Application Reference: 2026/0621

Site Address: 26 Church Street, Gawber, Barnsley, S75 2RH

Proposal: Proposed rear two storey and single storey flat roofed extension and raised decking and pergola to dwellinghouse.

Drawing Title
PROPOSED ELEVATIONS

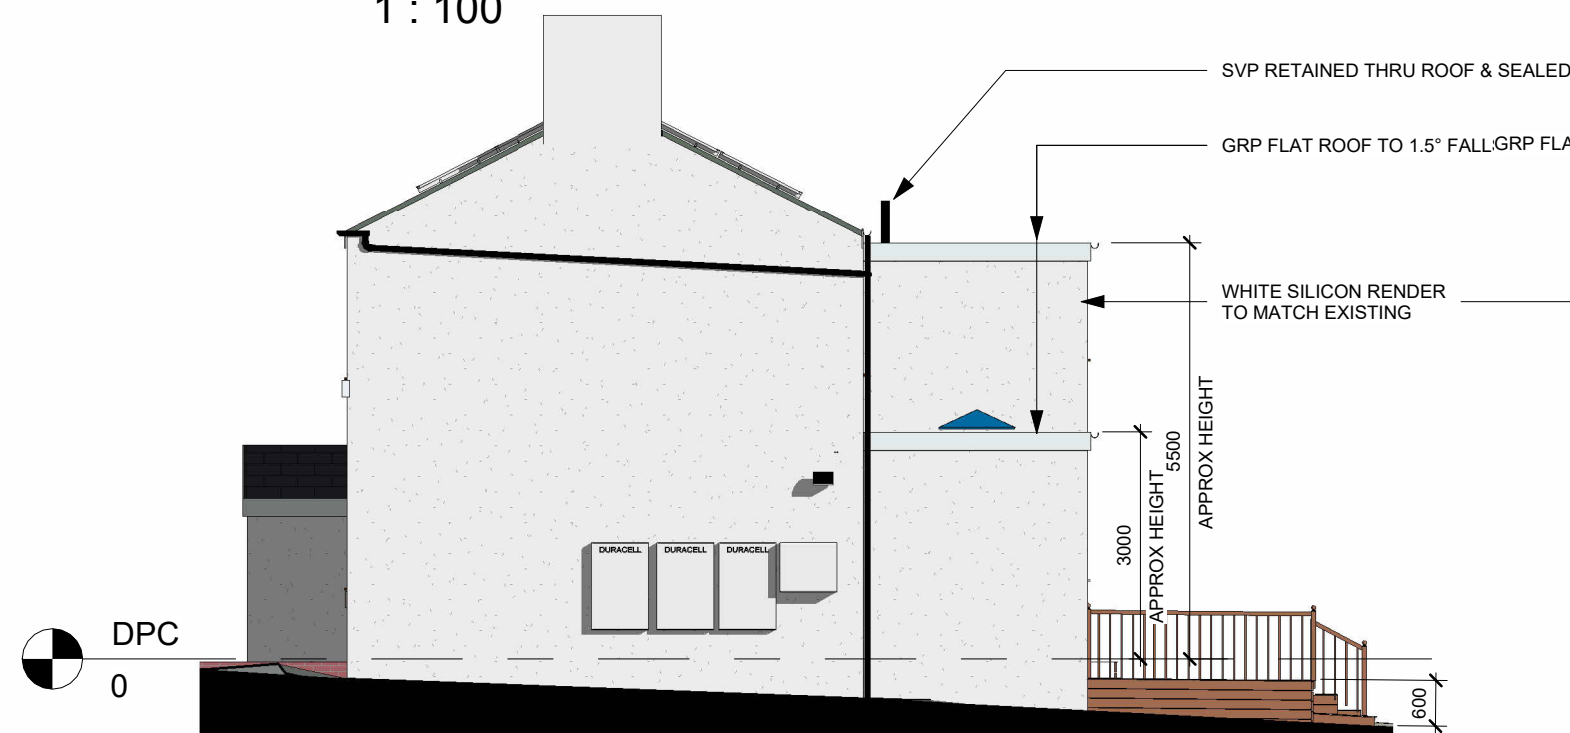
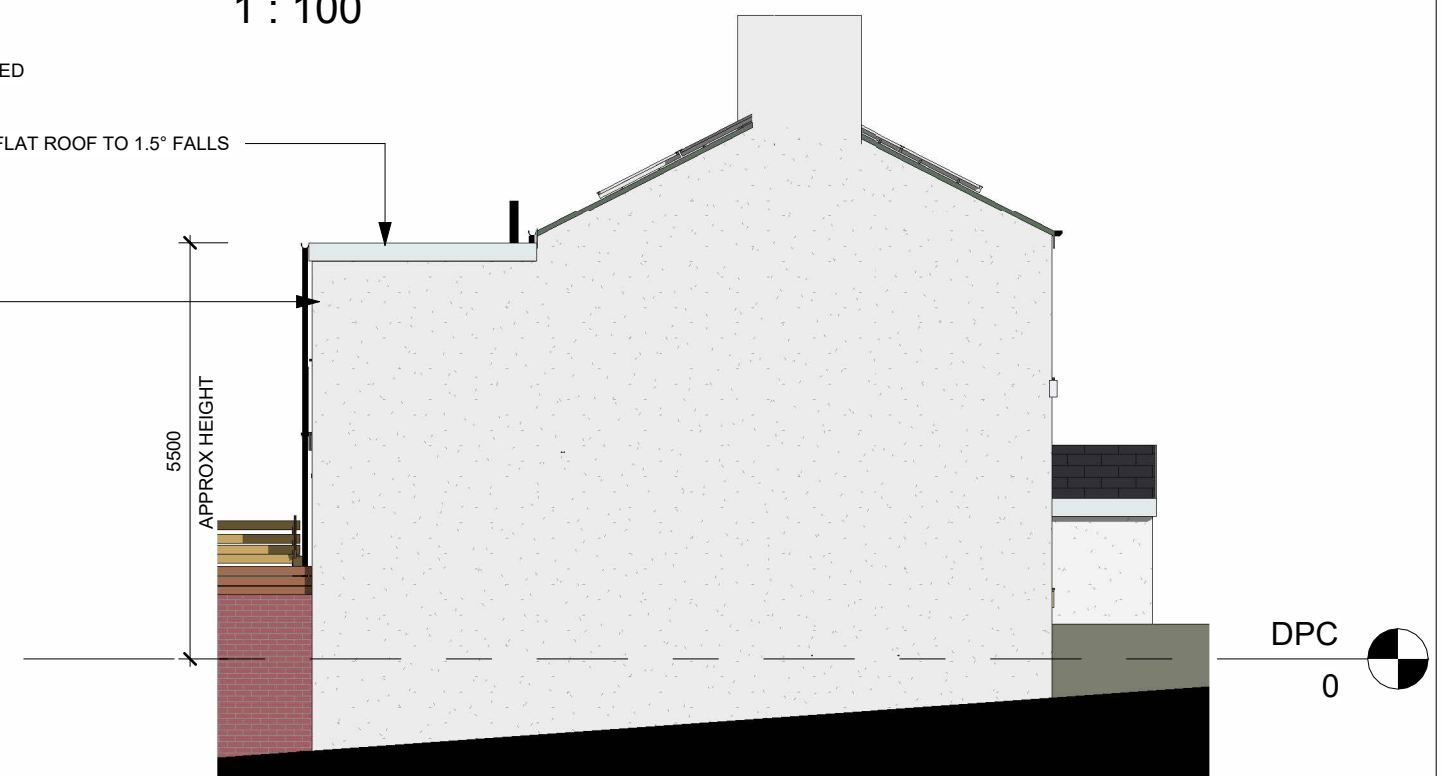
The proposed rear extension provides a modest rearward projection at approximately 3 metres and does not exceed the guidance within the House Extensions SPD. The use of a flat roof on the two-storey rear extension is not preferred and can be partially seen to the west, however given the extension is to the rear of the dwelling and predominantly hidden from the street, it would not be considered to detrimentally detract from the character of the street scene.

The proposed rear elevation ground floor window to service a W.C and the proposed rear elevation first floor window to service an en-suite shall both be conditioned to be obscured glazing in order to protect the privacy of both the applicant and neighbours to the rear of the site.

Amendments were requested to alter the proposed flat roof to a pitched roof, however given solar panels are already installed on the existing roof, the use of a pitched roof would impact the environmental sustainability of the dwelling. The use of a flat roof was therefore considered acceptable on this occasion.

3. The external materials shall match those used in the existing building.
Reason: In the interests of the visual amenities of the locality and in accordance with Local Plan Policy D1 High Quality Design and Place Making.
4. The ground floor rear elevation window servicing a W.C and the first-floor rear elevation window servicing an en-suite shall be of obscured glazing with an obscurity rating of no less than 4 in the Pilkington Glass Range (or an equivalent obscurity rating). The glazing shall be retained as such thereafter.
Reason: In order to safeguard amenities of the applicant and of the occupiers of dwelling to the rear in accordance with Local Plan Policy GD1 General Development.

PROPOSED FLOOR PLANS

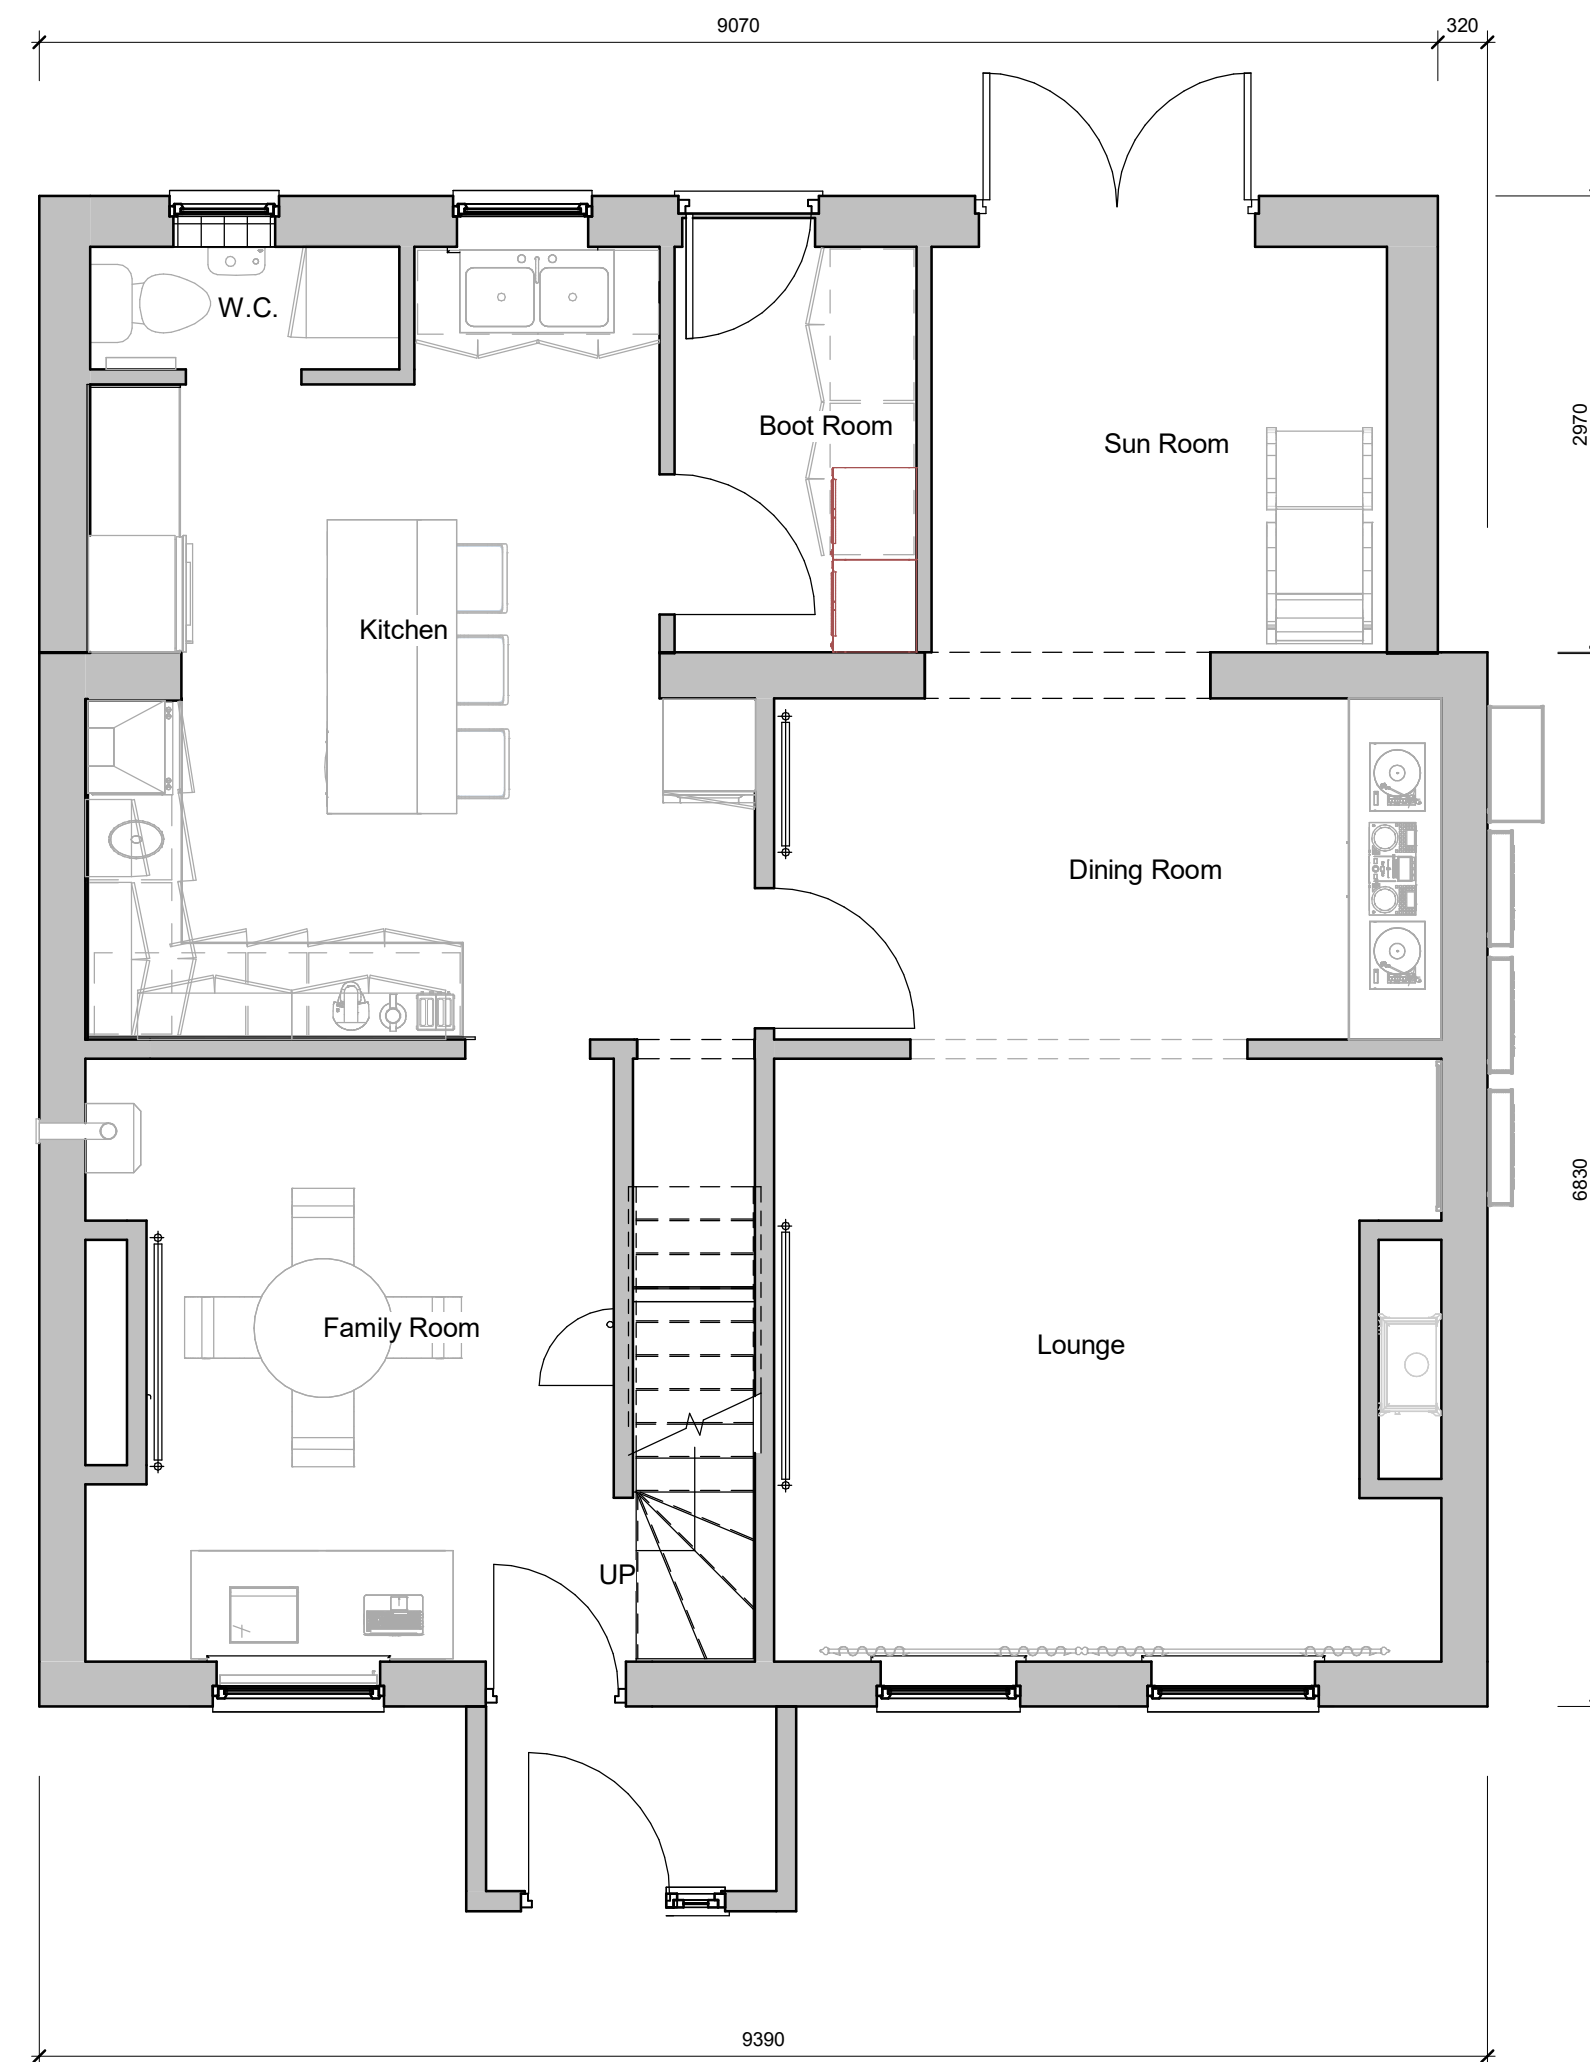
No glazing is proposed to the side elevations of the proposal, preventing any opportunity for direct overlooking. Glazing is proposed to the rear elevation at first floor level which would service a bedroom, however given the distance of the proposed rear elevation to the
